Your Ref: TR010062

Sport England Ref: PA/22/NW/CUC/62337

A66 Northern Trans-Pennine Project - Deadline 1 - Written Representation

Summary: Statutory Objection. Sport England would review and reconsider subject to further dialogue / completion of a Statement of Common Ground to:

Drawing Title
**Special Category Land Plans
Regulation 5(2)(i)
Sheet 2 of 2**

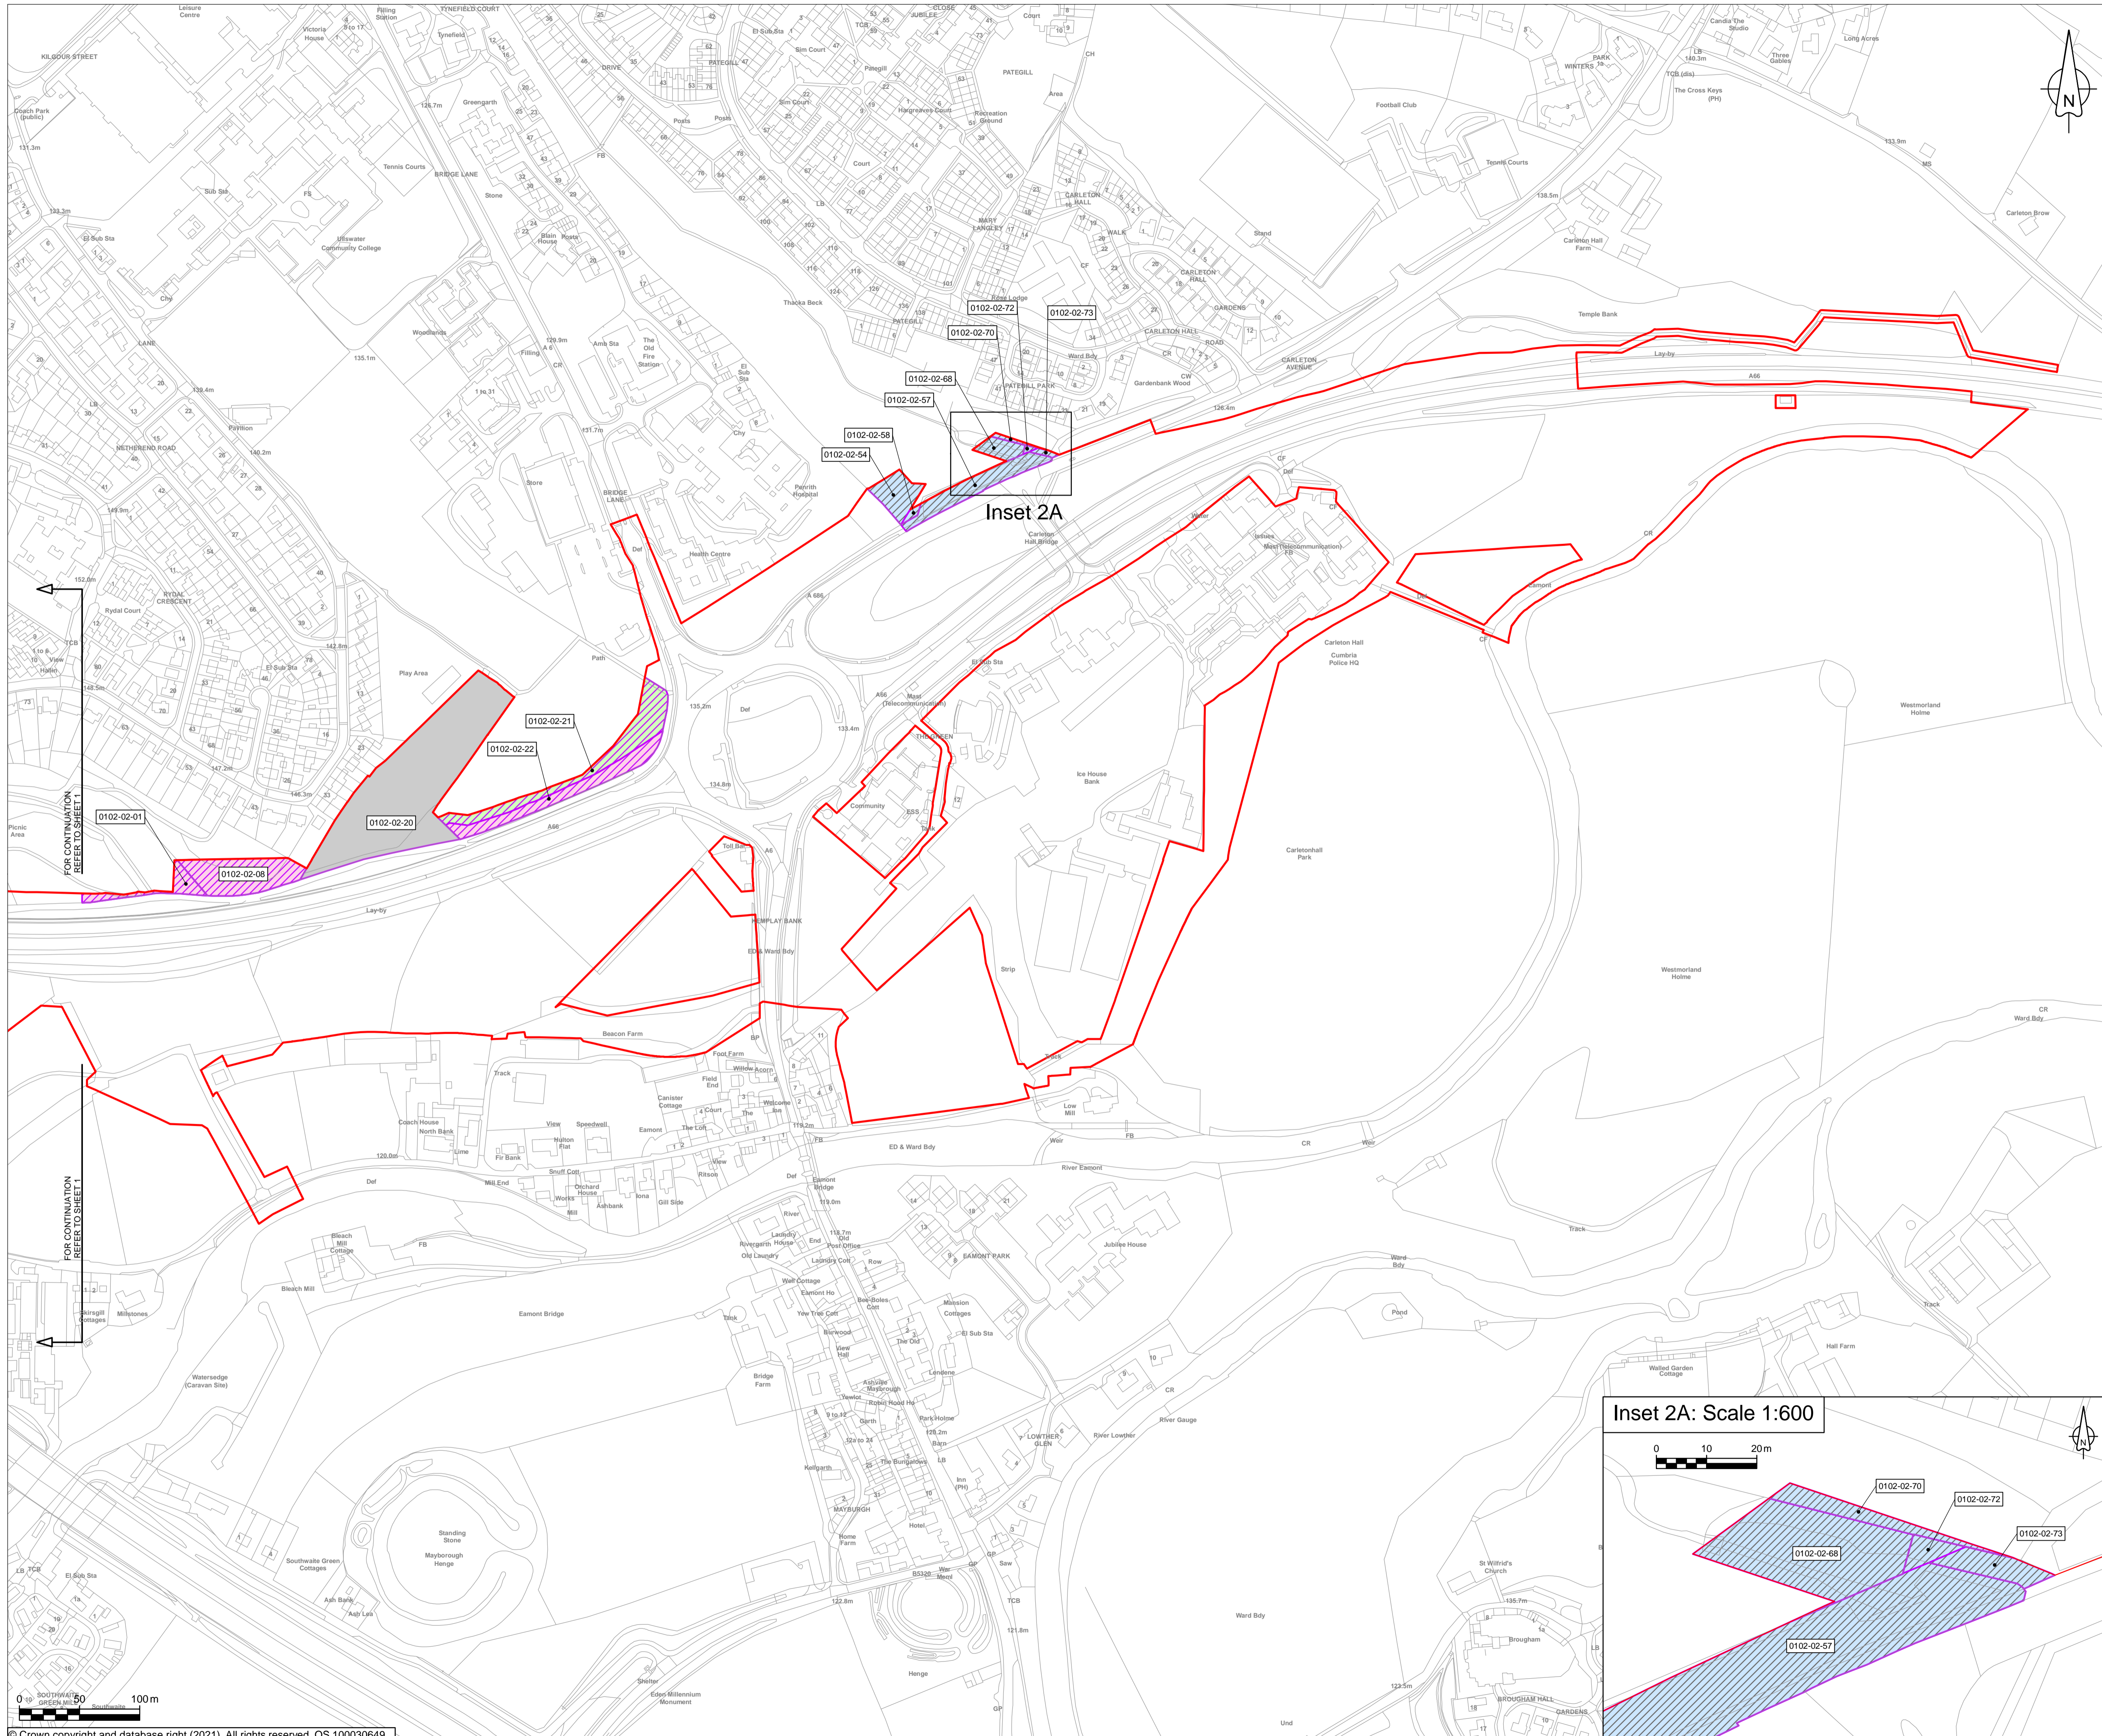
Loss of part of playing field to facilitate a slip road to the new Kemplay Bank Roundabout. It's not certain if the red edged site includes permanent or temporary loss of playing field land. (APP 011 sheet 2 of 2) This site affects a rugby pitch and it's not clear if ball stop

At this site (APP 011 & APP 041) shows loss of part of playing field to facilitate a slip road to the new Kemplay Bank Roundabout. It's not certain if the red edged site includes permanent or temporary loss of playing field land. This part of the development site affects a rugby pitch and it's not clear if ball stop fencing is proposed to prevent rugby balls leaving the field of play and landing on the A66. Paragraph 13.7.12 (APP 056 3.2

Mitigation for loss should be creation of new playing field here or elsewhere locally at the cost of the developer.
